Applicant's Response to S51 Advice

14 October 2024

Project Title: North Falls Offshore Wind Farm

Application Reference: EN010119

Drawing Title
**Work Plans -
 Key Plan (Onshore)**

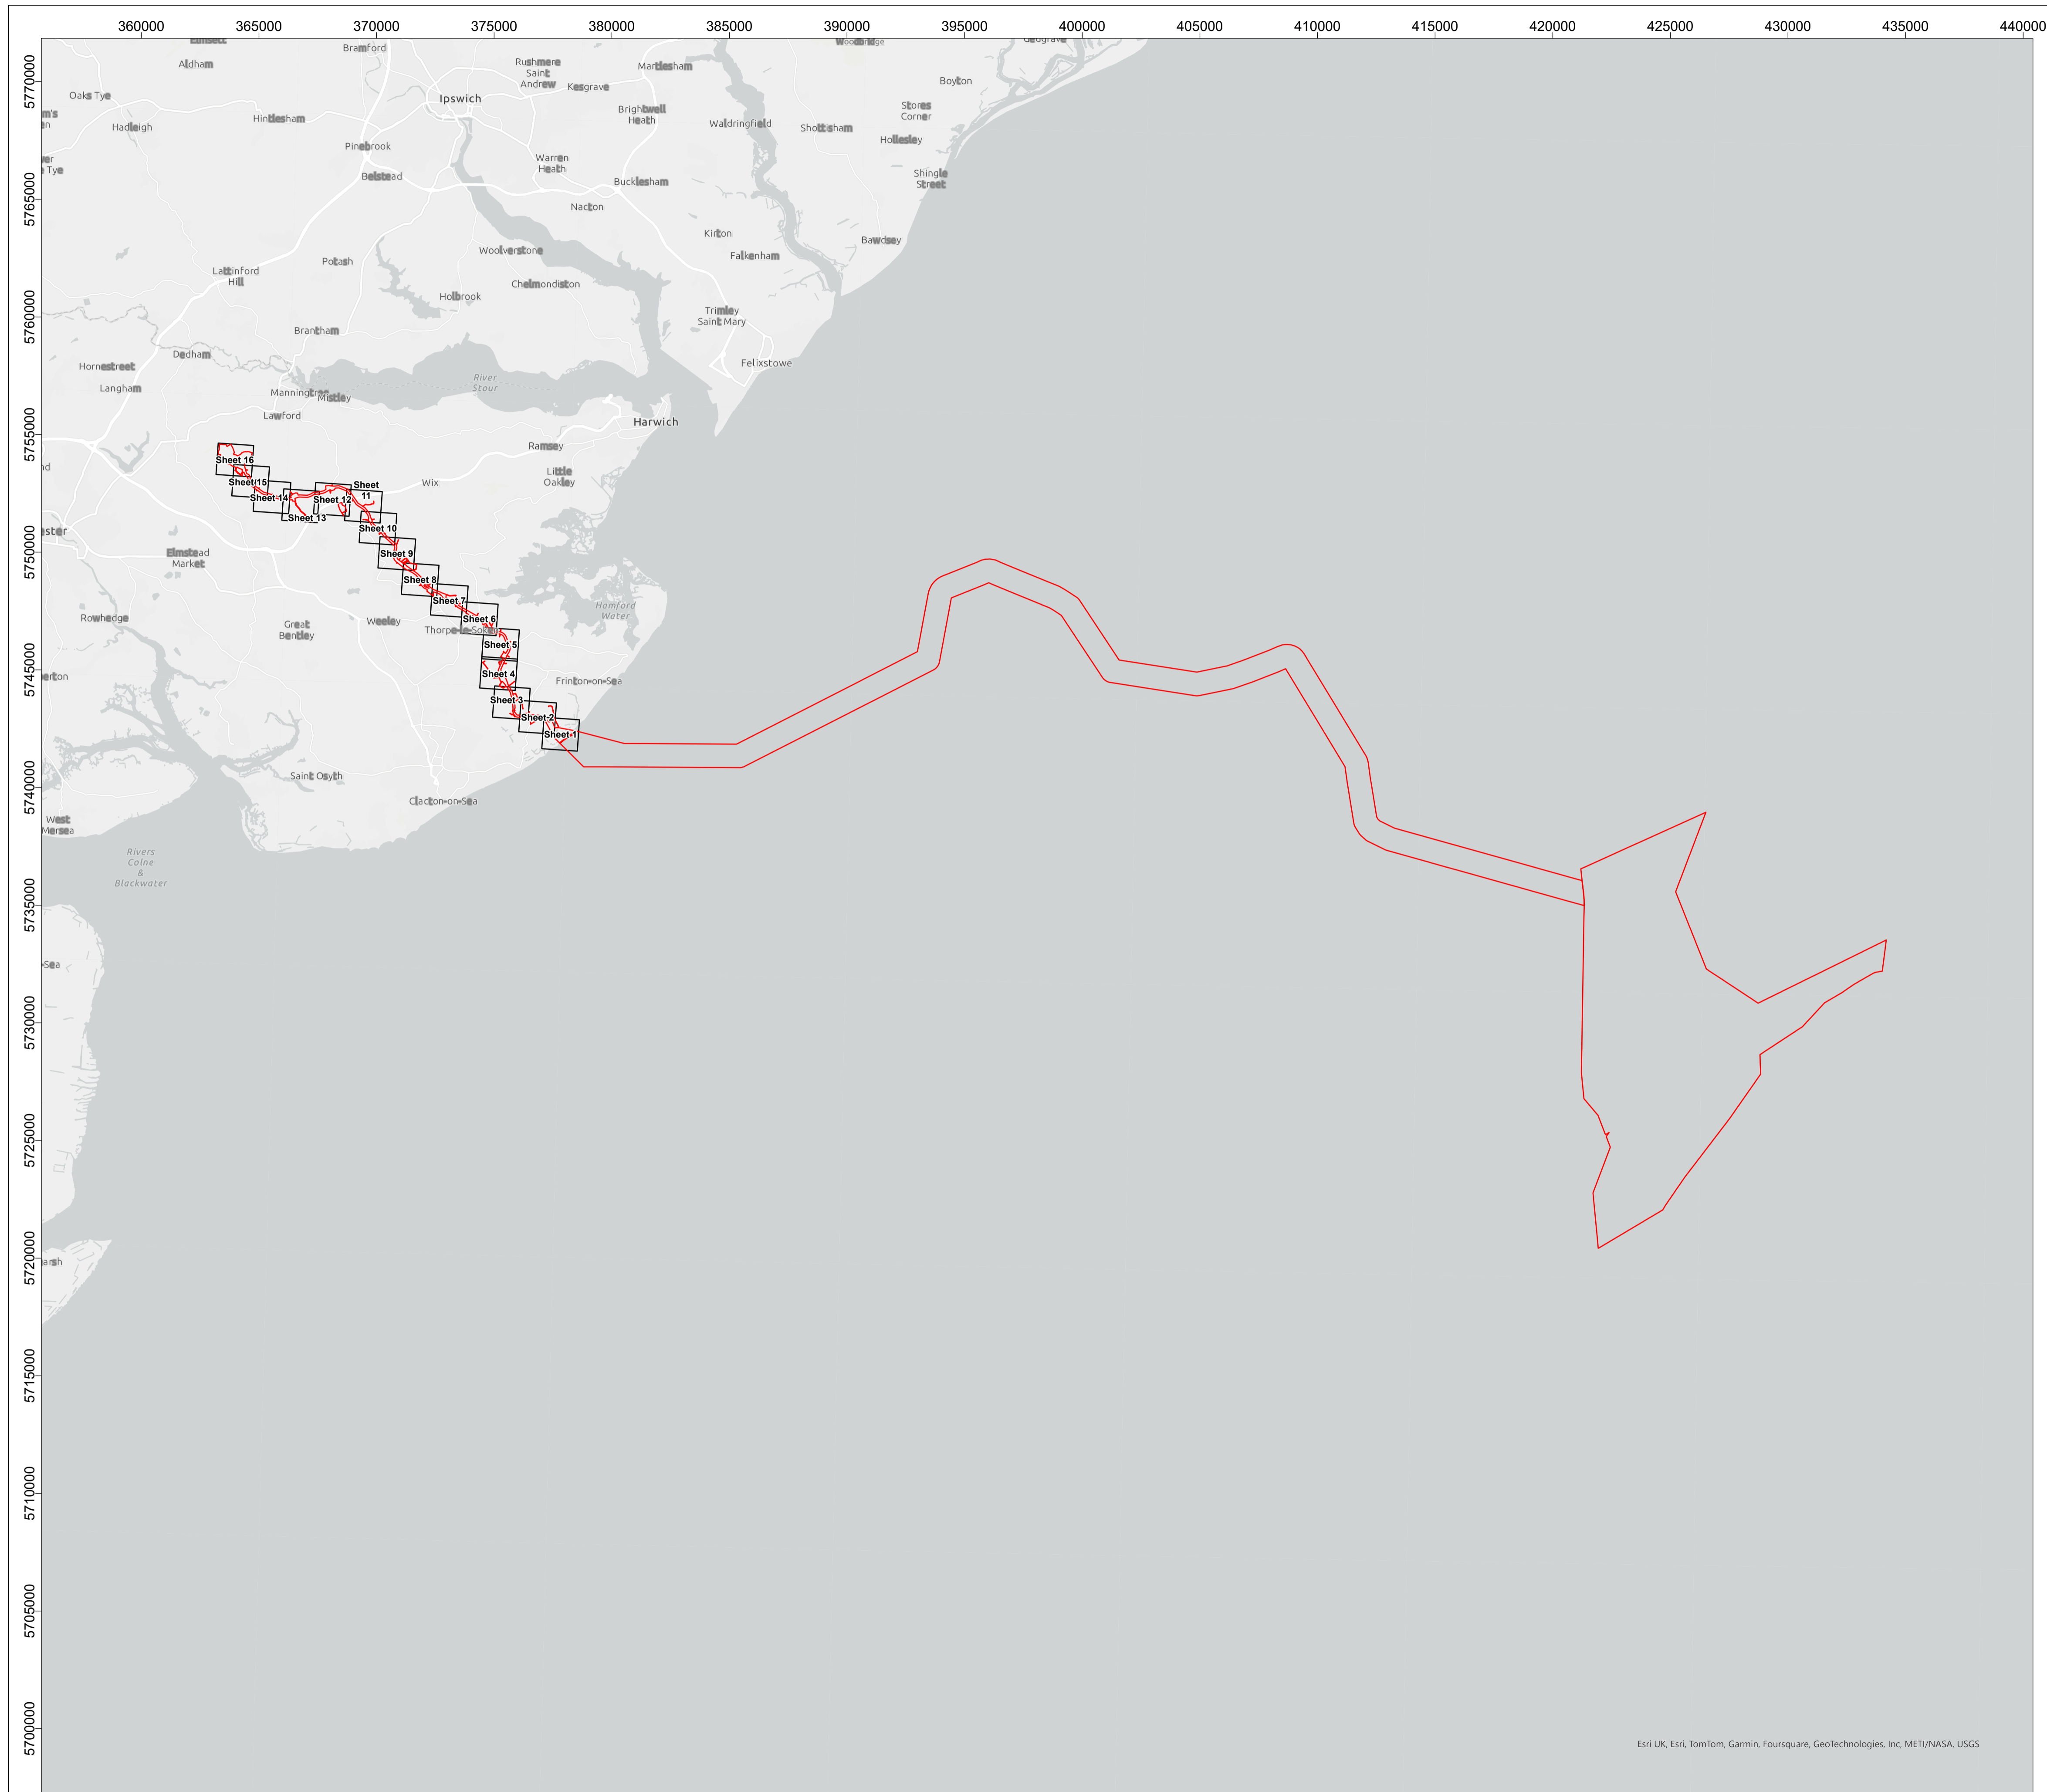
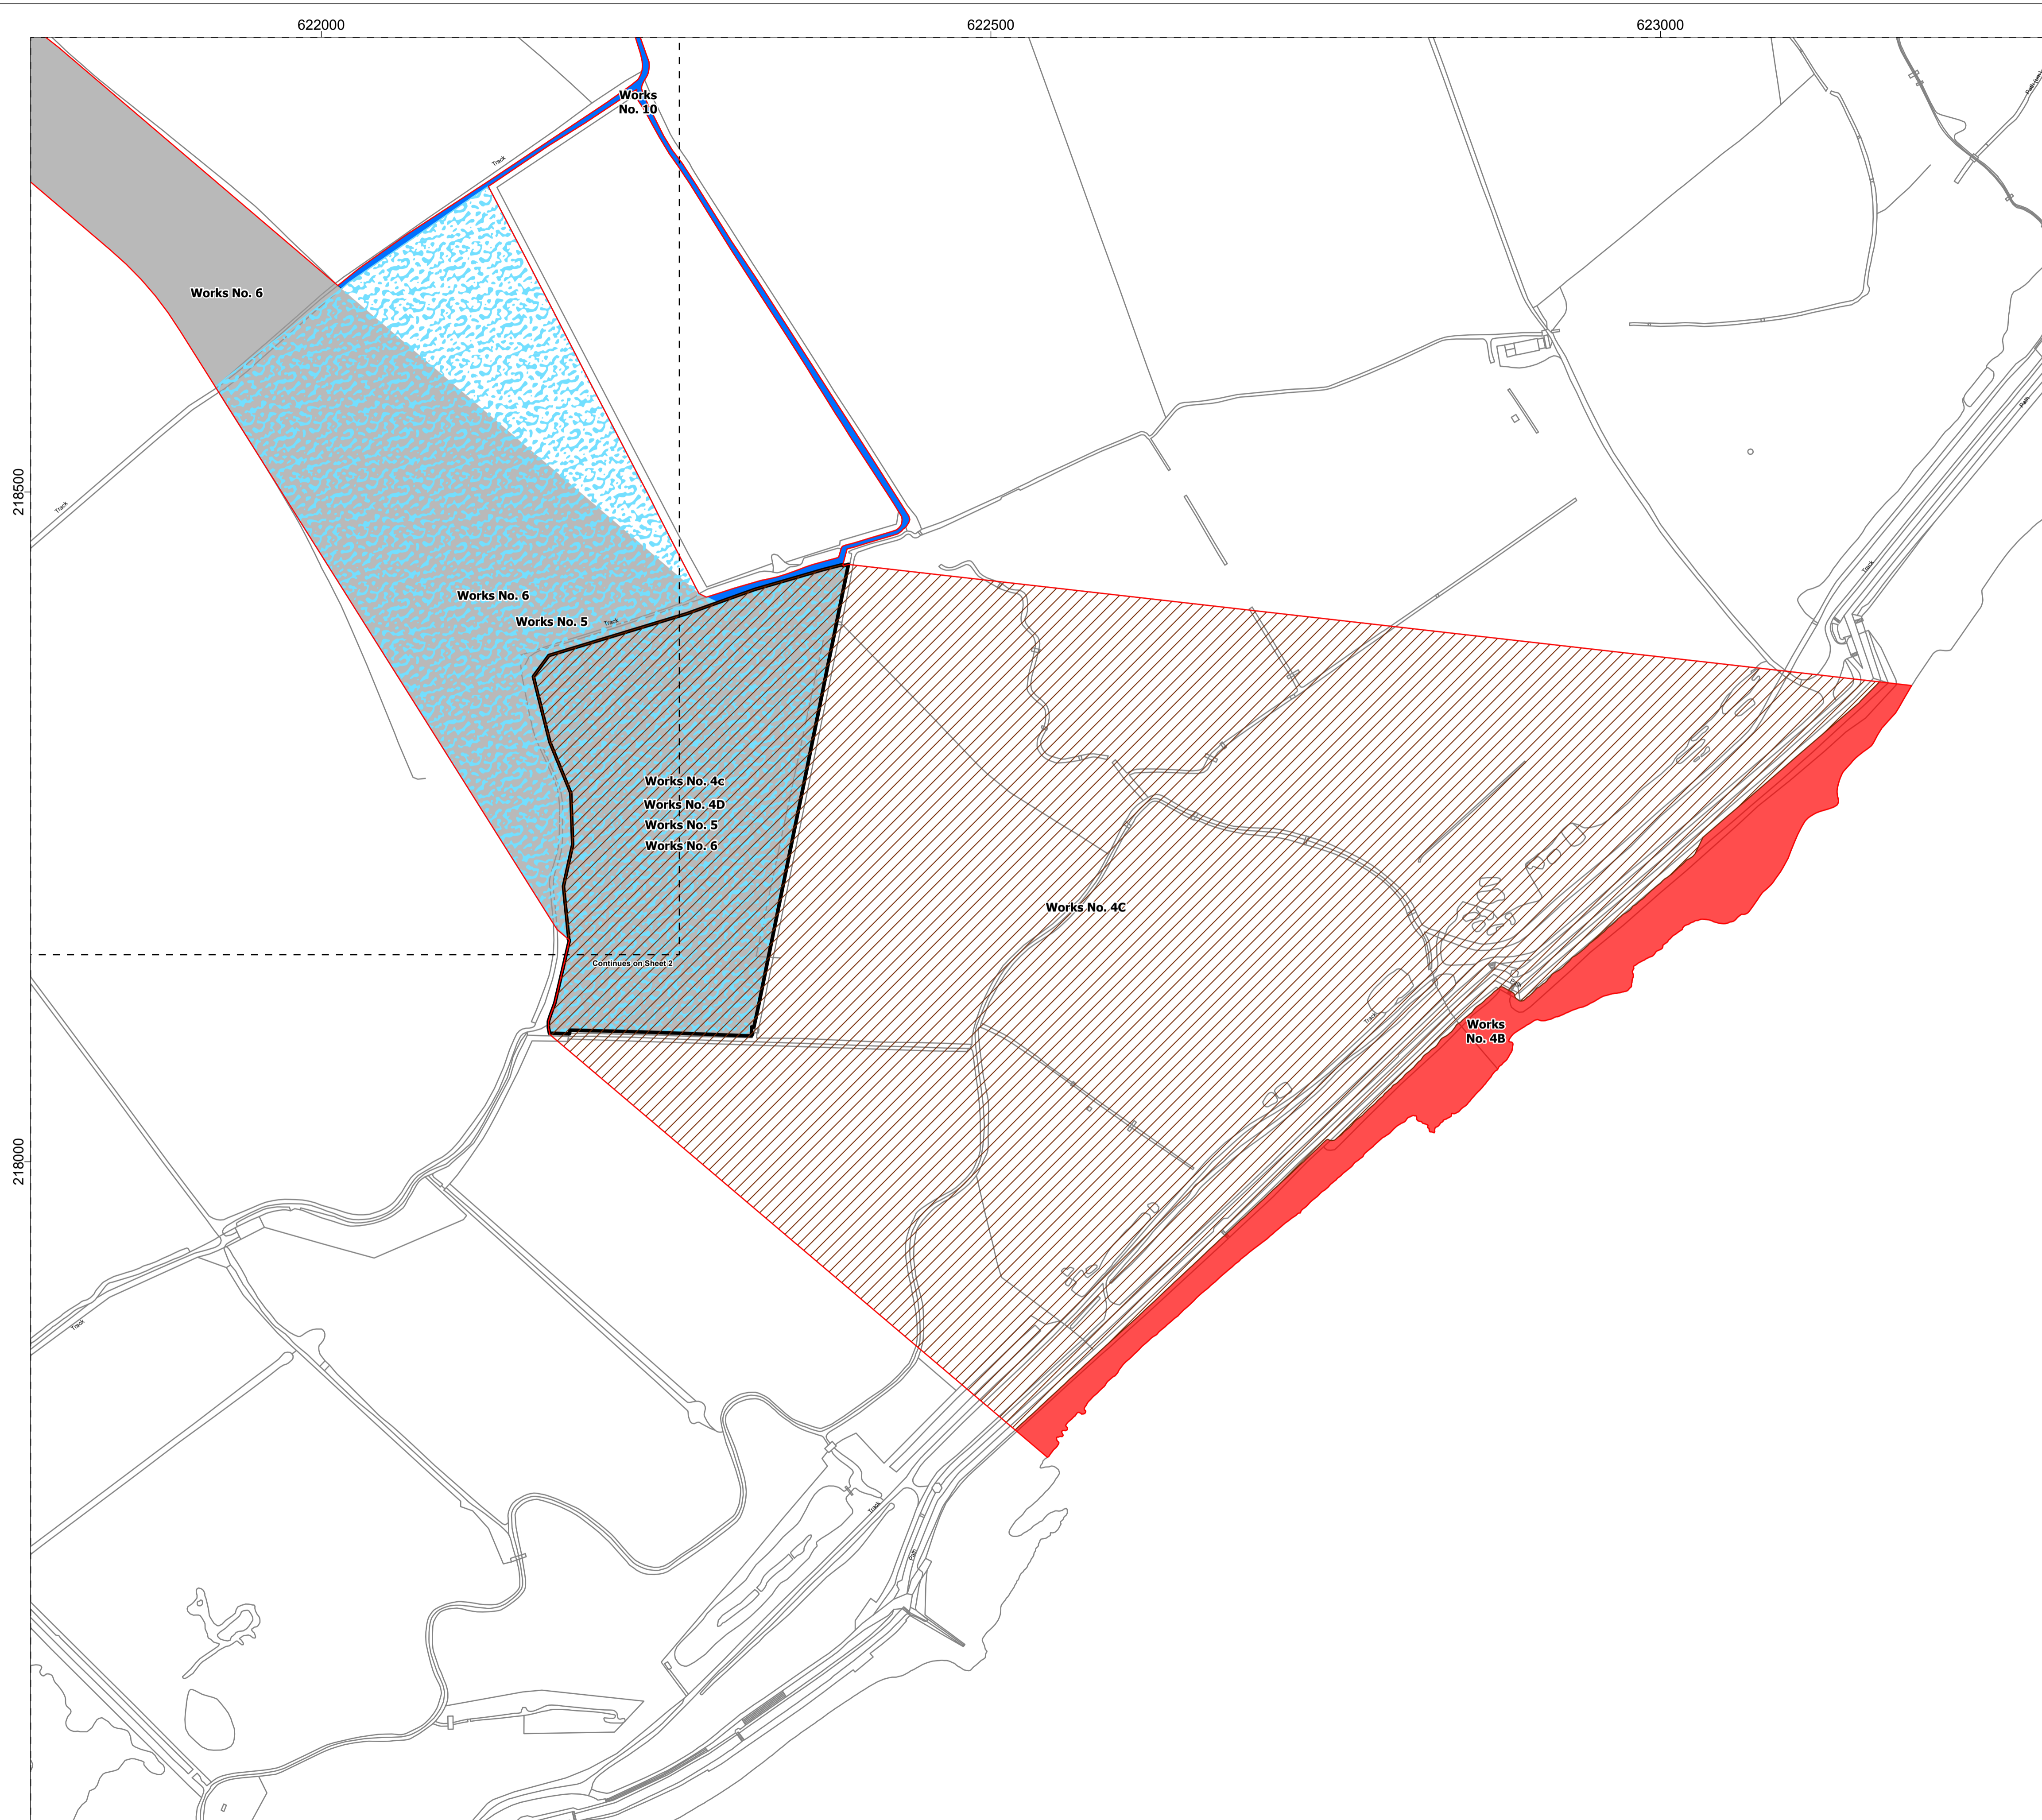
Works Plan Onshore (Doc 5.6)	
Comment or Query	Applicant's Response
<p>Summary descriptors are not provided for each work area.</p> <p>The Works Plans do not contain any identifying information, such as village or road names, which are shown on the Location Plans.</p> <p>Adding summary descriptors, local place and road names to the Works Plans would aid understanding for stakeholders.</p> <p>Similarly, the location of the 'red line' boundary must be clear in all areas. Once identifying information labels are added to the plans, please ensure that these can be digitally searched.</p>	<p>The Applicant has updated the Works Plans in response to this section 51 advice, which are submitted alongside this response.</p>
